STATE OF NORTH CAROLINA  
DEPARTMENT OF TRANSPORTATION

November 4, 2009

Subject: **Modification Request for Individual Section 404 Permit and to Individual Section 401 Certification for Section R-2518A**  
For US 19/US 19E Improvements  
From US 19/23 to SR 1421 (Windy Gap Road)  
Yancey County  
NCDOT Division 13  
State Project Numbers 6.869005T and 6.909001T  
T.I.P. Project Number R-2518A  
Debit \$570.00 from WBS Element 34634.1.2

PROJECT REFERENCE NO.	SHEET NO.
	R-2518A	30
ROADWAY DESIGN ENGINEER	HYDRAULICS ENGINEER	
CONST. REV.		
R/W REV.

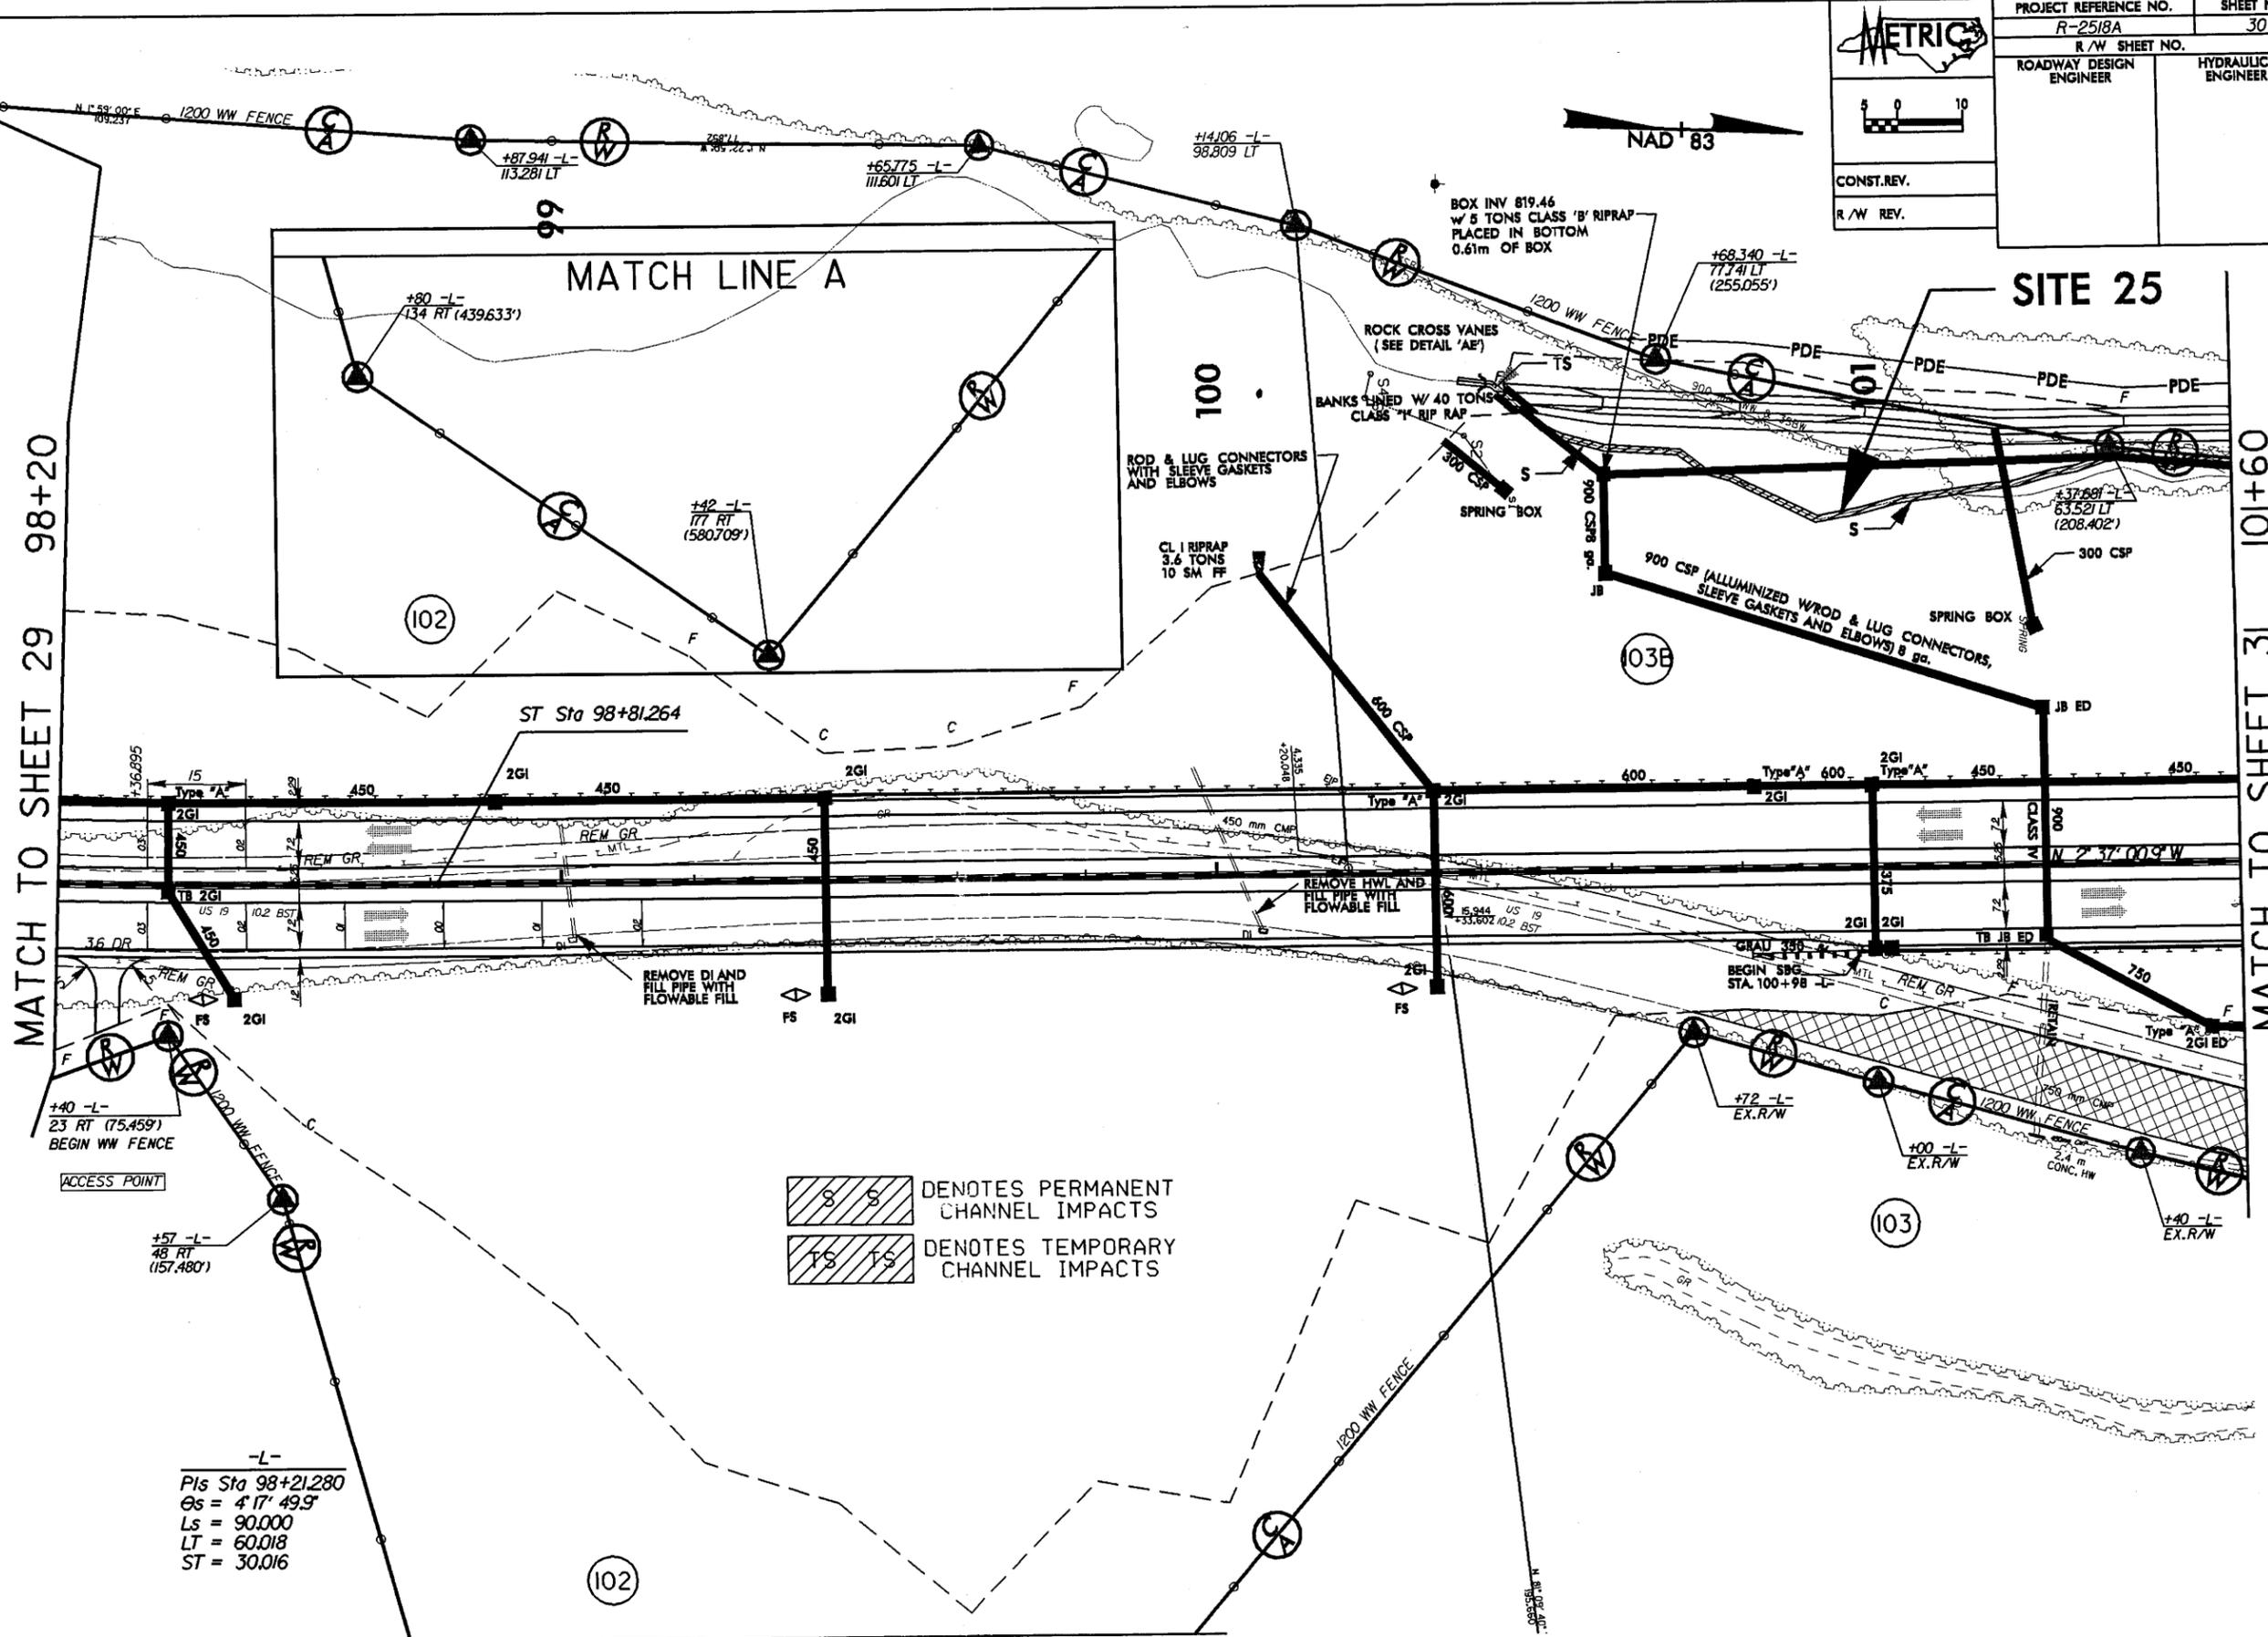
During the merger process a retaining wall was recommended by the Corps and the North Carolina Division of Water Quality (NCDWQ) to avoid impacts to Ivy Gap Branch. The retaining wall was originally listed as an Avoidance and Minimization measure in the June 26, 2007 Individual Permit Application. During the design process NCDOT anticipated a small toe wall approximately 10-20 feet in height. As the design progressed and geotechnical studies were completed it was determined that, due to poor soil conditions, a rock buttress was needed to prevent wall settlement and failure. Due to the buttress and proximity of the stream and roadway; the wall has increased to approximately 1000' in length, ranging from 85' to 100' in height with a construction cost of over 5 million dollars.

The fill slope that will replace the retaining wall will impact **1228** LF of Ivy Gap Branch (WSII-HQW) in the French Broad River Basin (HUC 06010105). Ivy Gap Branch from Station 97+70 to 105+00 -L- was identified as a preservation site; Site Q in Stream Mitigation Plan, US 19, R-2518A On-Site Mitigation, Madison County, North Carolina dated August 2006. The mitigation ratio that was used for preservation was 4:1. Therefore, the 1228 LF of impacts to the stream will reduce the credit received in the preservation by 307 LF (1228 LF/4). Therefore, NCDOT will impact **1228** LF of stream plus lose 307 LF of credit already used on the project resulting in a new mitigation requirement of **1535** LF. At the request of the North Carolina Division of Water Quality; NCDOT will pursue the mitigation through EEP at a 3:1 ratio.
